Application No: AB/12/21/PL
Site Address: Old Bank House 3 High Street Arundel BN18 9AD
Description of works: Internal & external alterations to existing building to facilitate the change of use to a residential dwelling granted under AB/122/20/PD to include demolition of single storey rear extension, removal of rear external chimney, change existing window to front elevation to entrance door & new french doors to rear elevation. This application affects the setting of a listed building, affects the character & appearance of the Arundel Conservation area & is in CIL Zone 2 (Zero Rated) as other development.

OWPC36286

Project:-			
Old Bank House 3 High Street Arundel West Sussex			
Title:-			
Proposed Site Plan			
Client:-			
Moor Construction Ltd			
Scale:-			
1:100 (@A1)			
Drawn By:-	PJD	Checked By:-	PJD
Date:-	12/02/21	Date:-	12/02/21
Job.No:-	200042	Drg.No:-	22
		Rev:-	A

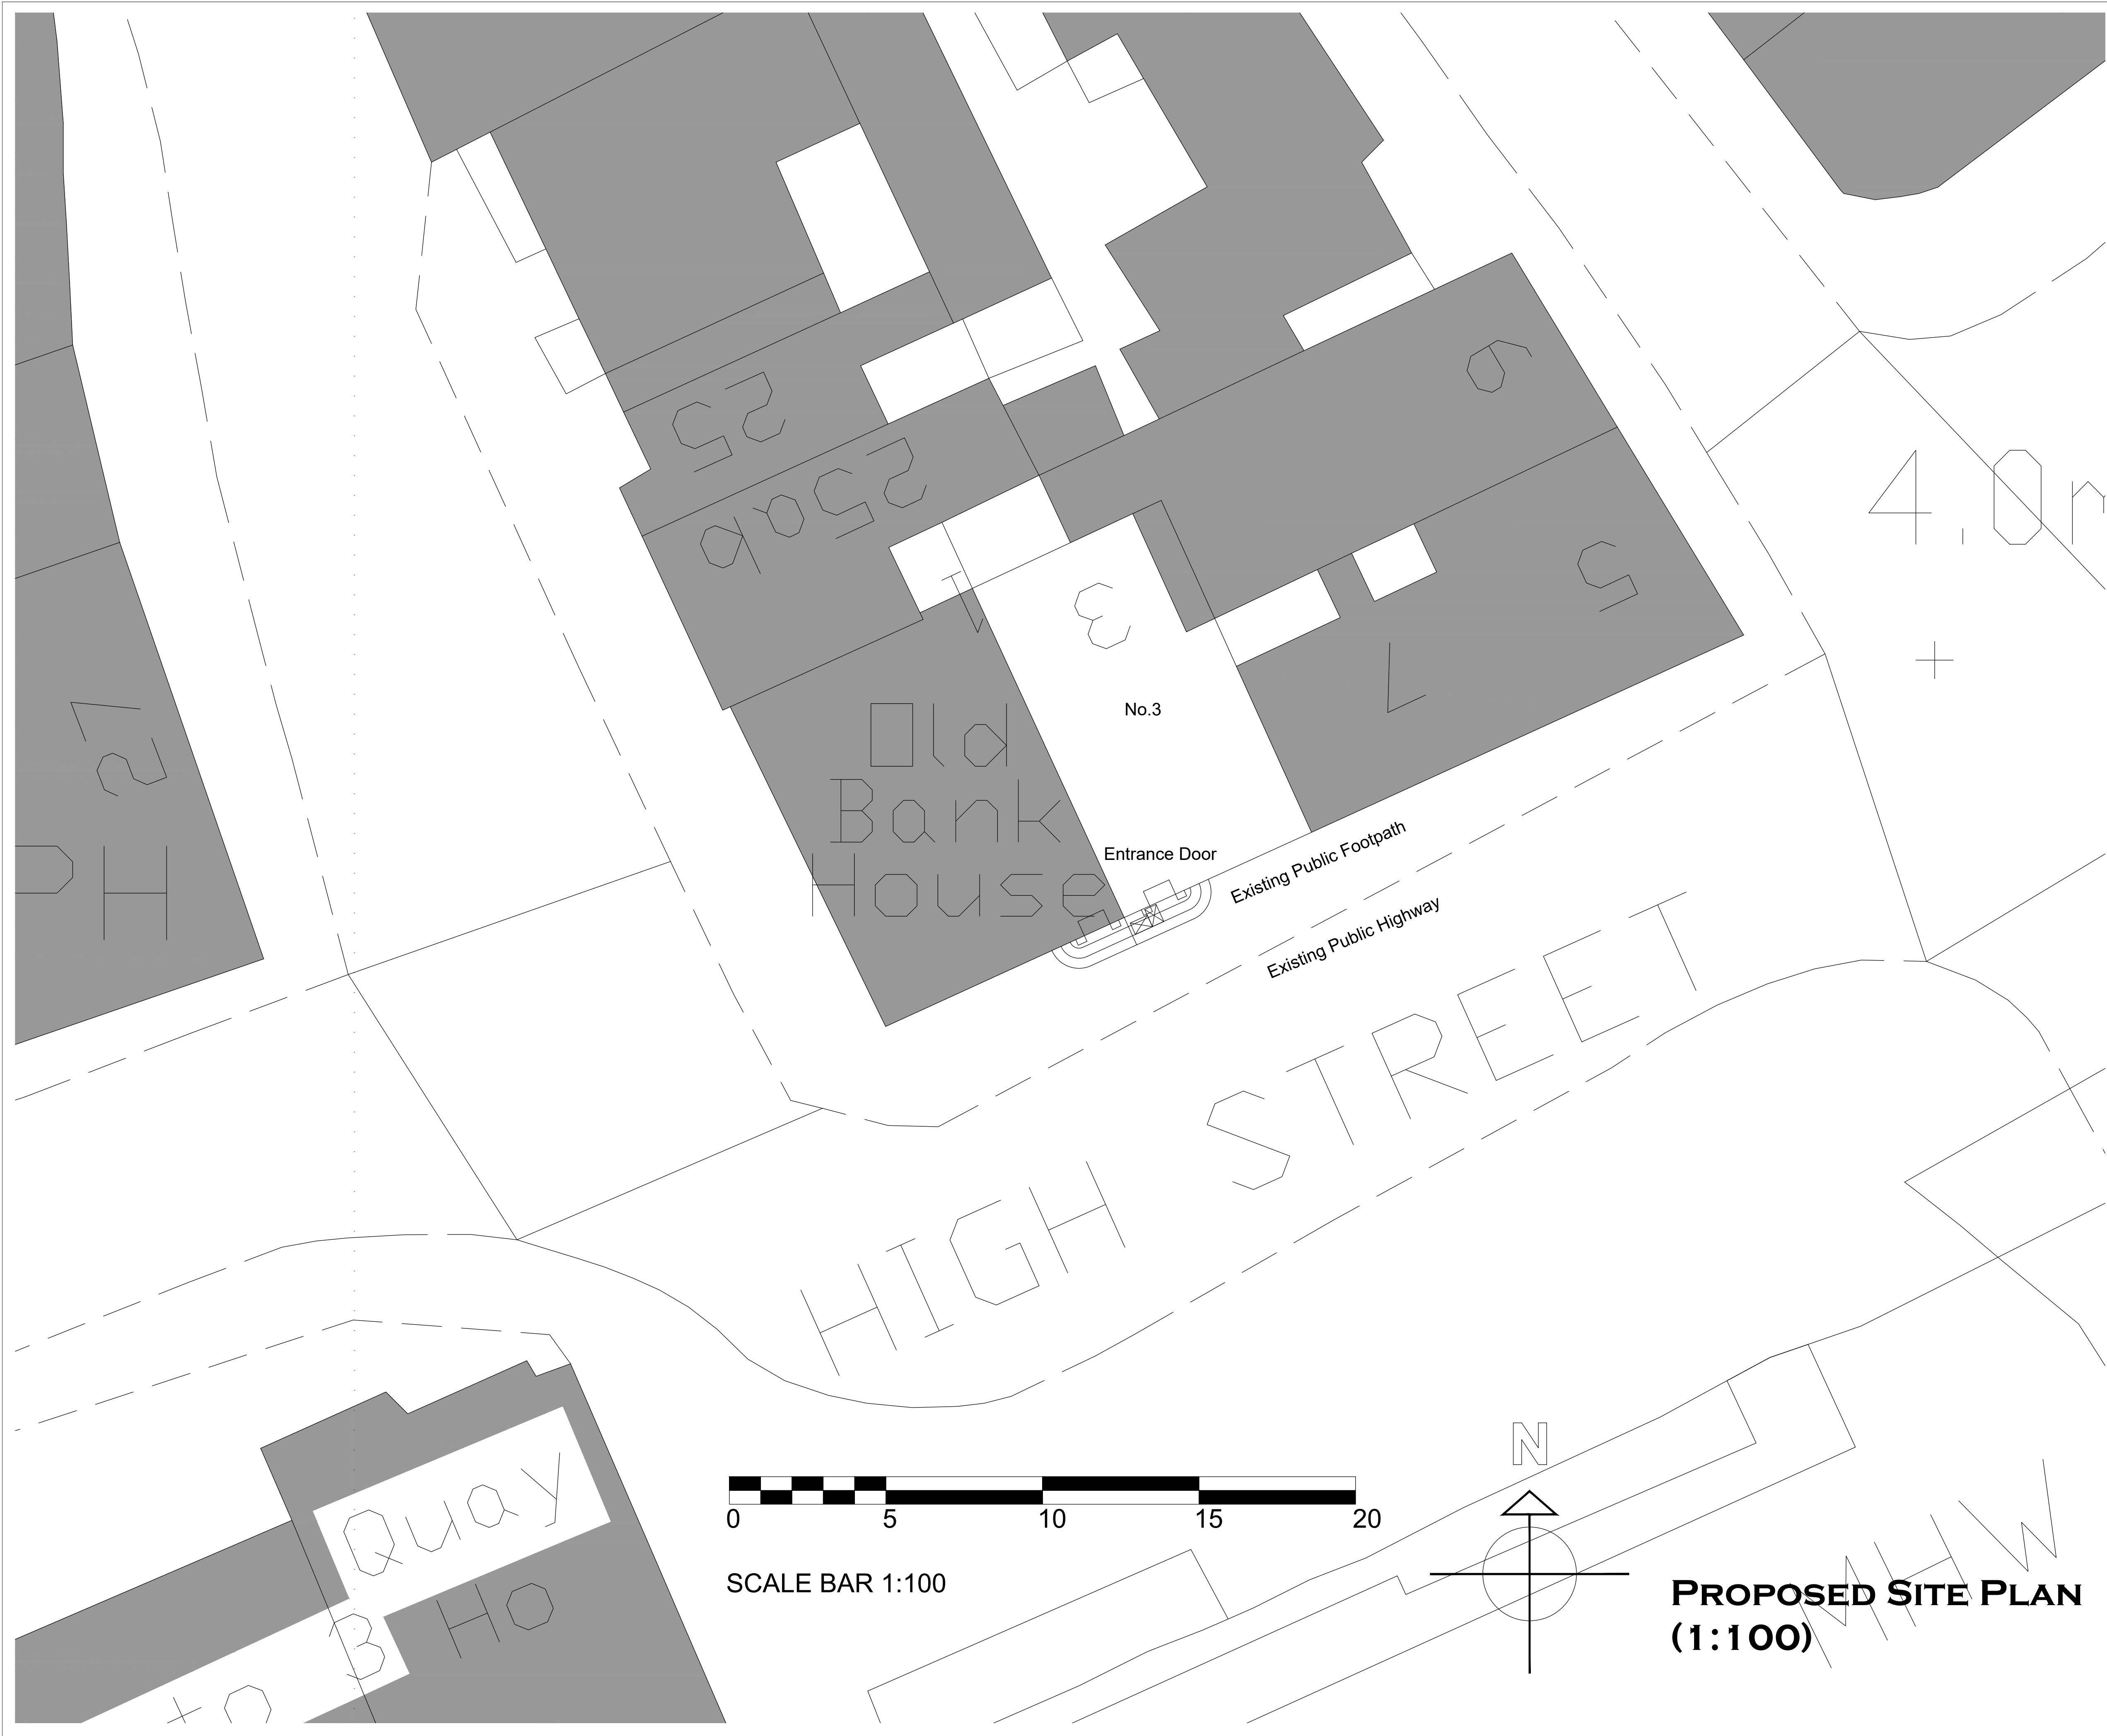
The following comments are in addition to the comments already submitted by the Panel. Details of the proposed new steps have now been submitted but they should be finished in stone ashlar to match those of the abutting listed building. The use of a trowelled cement finish is not acceptable given the heritage asset context. No detailed drawings are given of the proposed doorcase with pedimented hood which is shown in outline on the proposed front elevation and it is still not clear whether it is part of the application proposals or not.
